Memorandum
Planning and Urban Development Department
Planning Division

Date: February 23, 2018

Re: MMC East Tower and Visitor Garage Vertical Expansion
 22 Bramhall Street
 Maine Medical Center (MMC)

Project #: 2017-289 CBL: 053D007/054H001/064C001

- a. Week one – build crane.
- b. Week 2-7 – erect precast garage.
- c. Week 8 – dismantle crane.

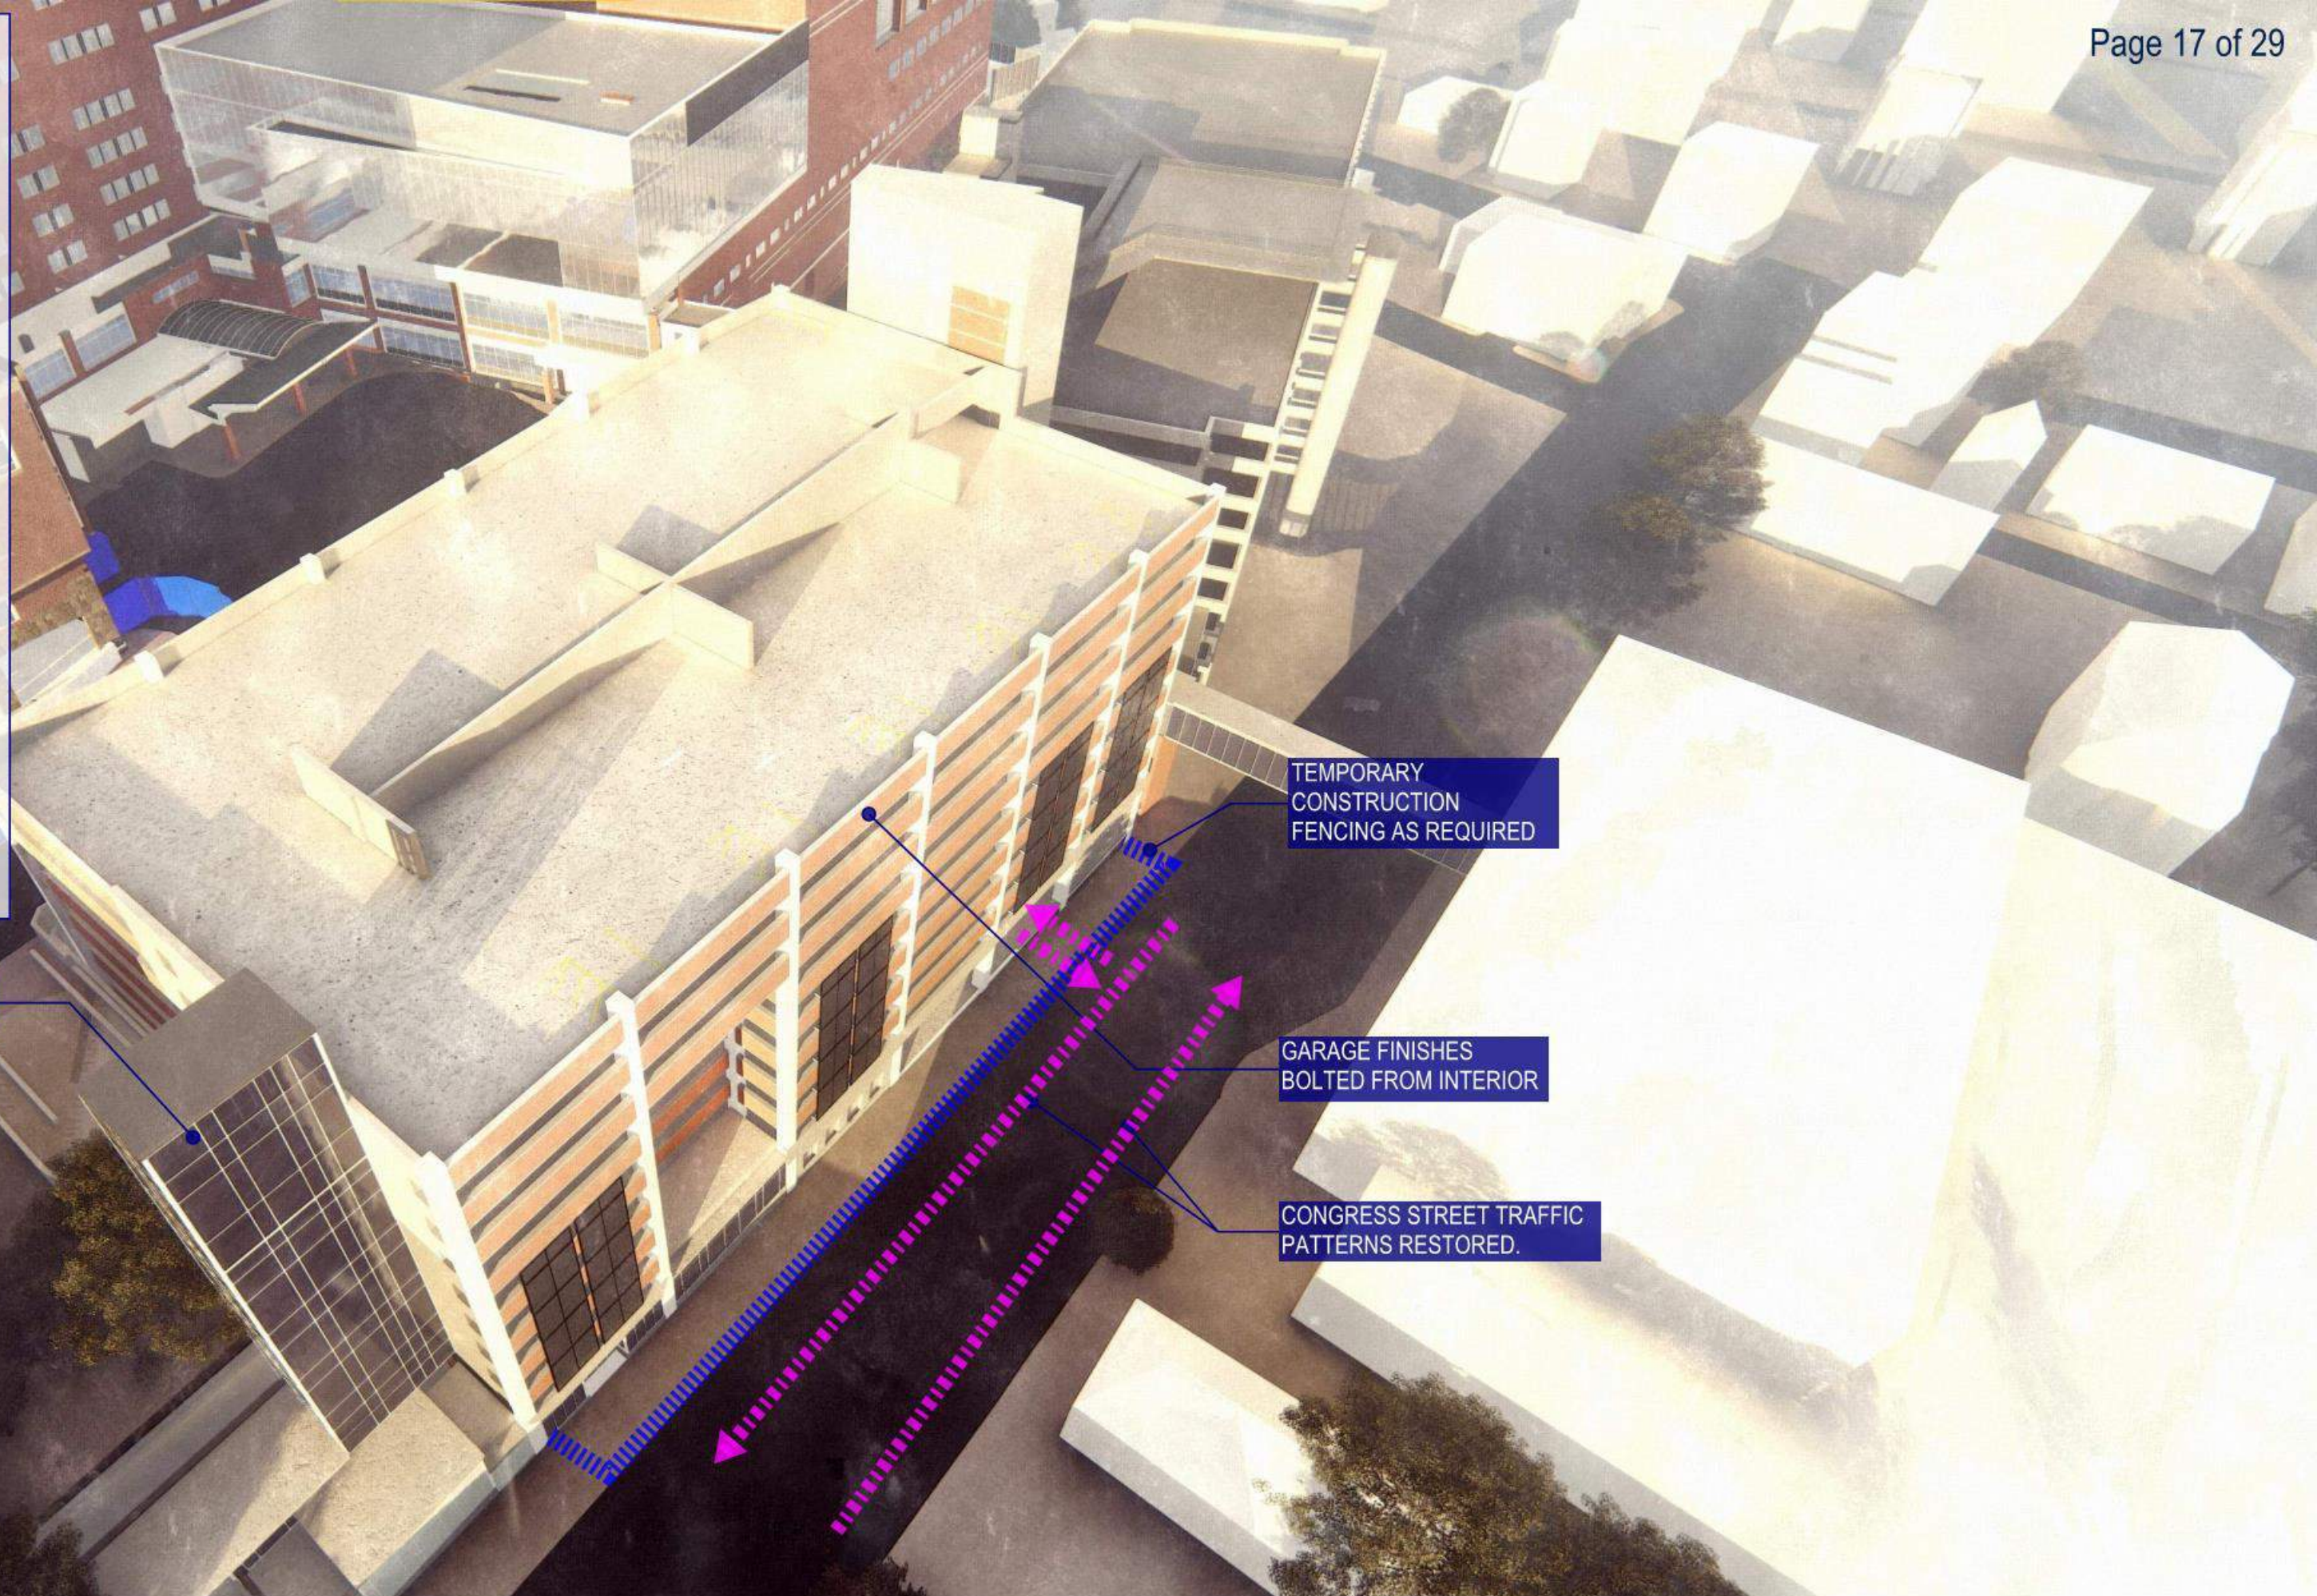
At the review “check in” meetings (Att. 6) there was general agreement that the 8 week closure of Congress Street presented the safest approach with the fewest “unknowns”, but there remain some concerns that require further discussion:

- The feasibility of the pedestrian route alongside the crane in Congress Street (the crane at right is the type of crane that will be needed)
- The delivery route for the steel for the East Tower is proposed to go via Washington Avenue and Congress Street
- Delivery hours to avoid peak traffic times
- Enforcement of contractor employee parking not to be on local streets
- Introduction of penalties and other measures to ensure the closure is reopened prior the July 4th holiday weekend.
